17 November 2021

**Subject: Gunlake Quarry Continuation Project (SSD 12469087)**

A review of the Environmental Impact Statement prepared by EMM Consulting has been undertaken in relation to the above proposal and a report was considered at the 16 November 2021 Council Meeting. At this meeting, Council resolved:

APPENDIX 3: PRIMARY AND SECONDARY TRANSPORT ROUTE

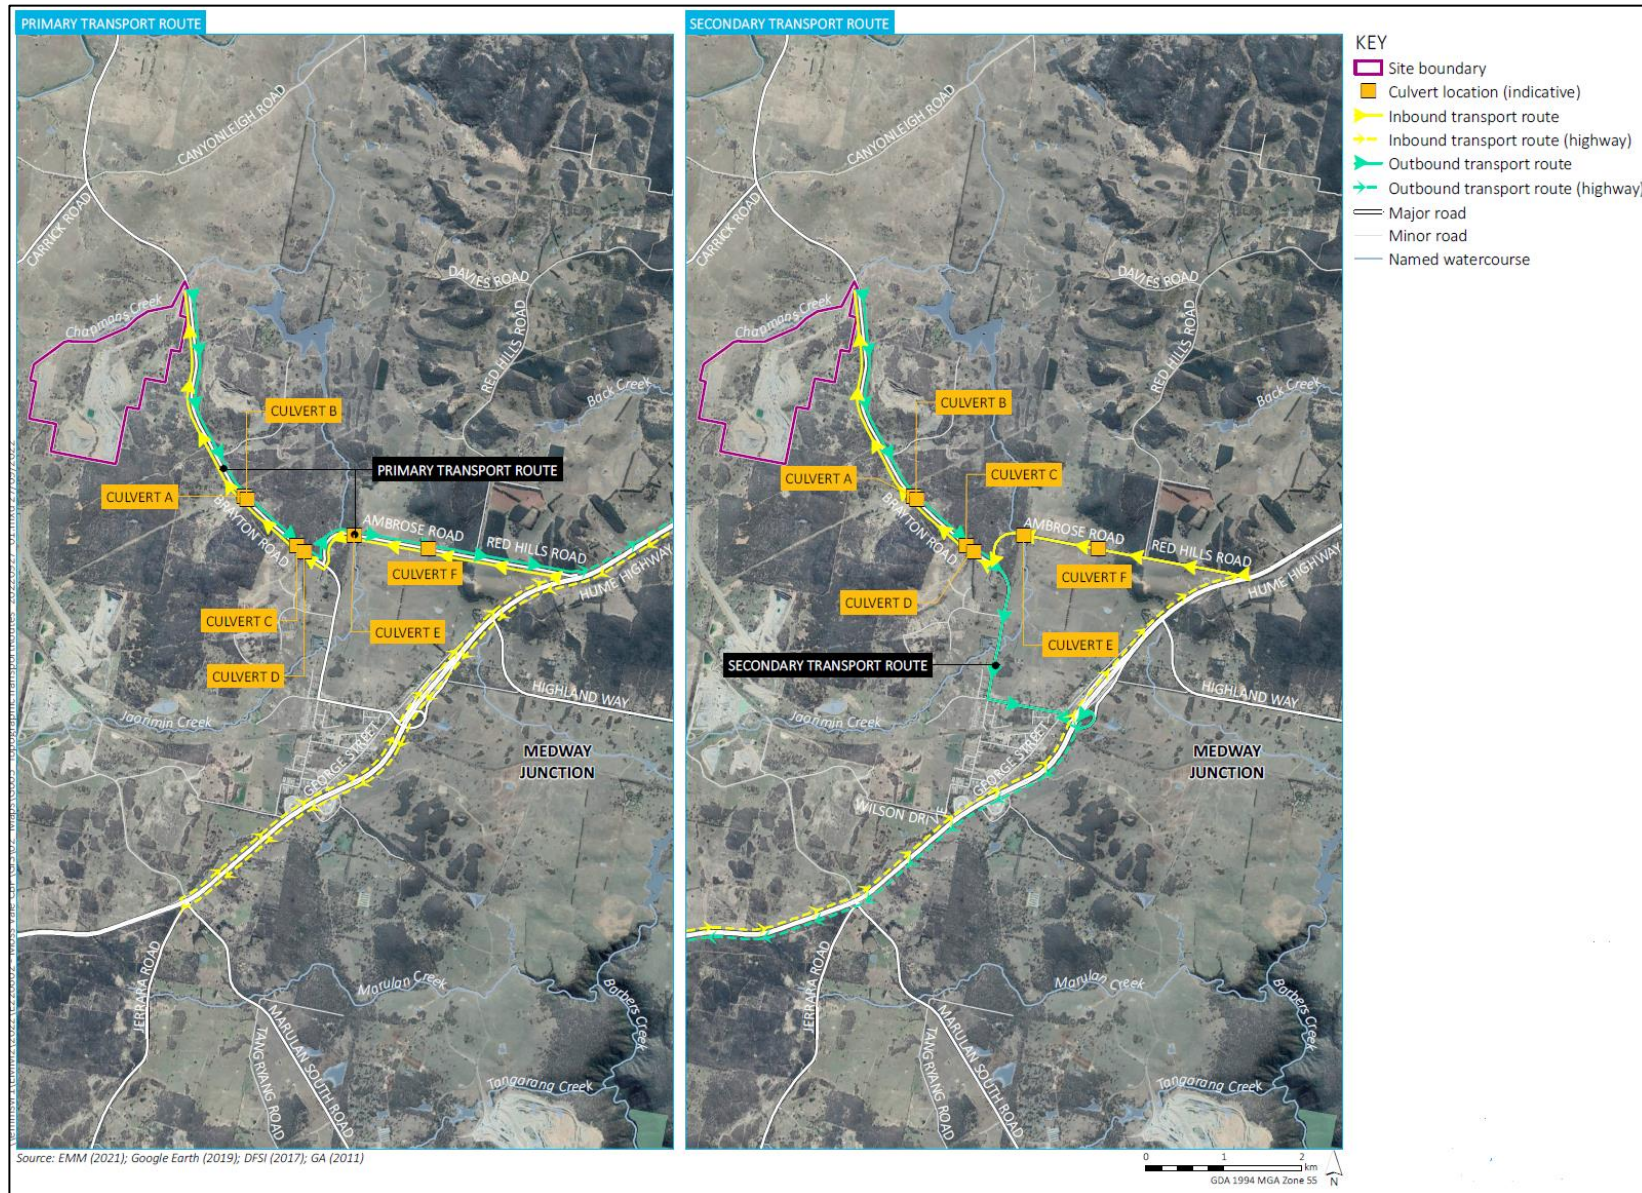
- i. A structural assessment by an Independent appropriately qualified engineering consultant of all bridges and culverts be undertaken for proposed vehicles exceeding the current allowable load limit along the Primary Transport Route.***

- ii. Widening of bridges and culverts is required on the primary transport route to allow a consistent wide centre line treatment to be implemented.***

- iv. An independent traffic consultant be engaged to investigate any lighting and/or delineation upgrade at all intersections along the primary transport route and if upgrades are warranted by the independent traffic consultant then those upgrades to be funded and installed by Gunlake***

- v. The intersection of the Brayton Road and Ambrose Road intersection should be assessed to ensure it meets the relevant Austroads Guidelines,***
- vi. The sight distance be reviewed at the intersection of Red Hills Road and Ambrose Road for vehicles existing Red Hills Road. If improvements are identified by the review they be implemented in accordance with Austroads Guidelines.***

- vii. *The speed limit for the Primary haulage route should be reduced to 80kmh for all vehicles. It is noted that the applicant, Council, the Gunlake Community Consultative Committee and the Local Member of Parliament have all previously endorsed and advocated for this outcome.*

- viii. *Minimum 3m trafficable clear zones should be installed for the full length of the Primary Haulage route – with the exception of bridges, culverts and other area agreed by the General Manager where it is impracticable to do so - and be constructed in line with Austroads guidelines for heavy vehicle use.*

- ix. *The actions identified in the Road Safety Assessment Report for the Primary Transport Route be implemented*
  - x. *A pavement assessment report by independent geotechnical consultant be commissioned to investigate the integrity of the existing pavement and to determine if the pavement will achieve a ten (10) year pavement life with the projected heavy traffic volumes.*
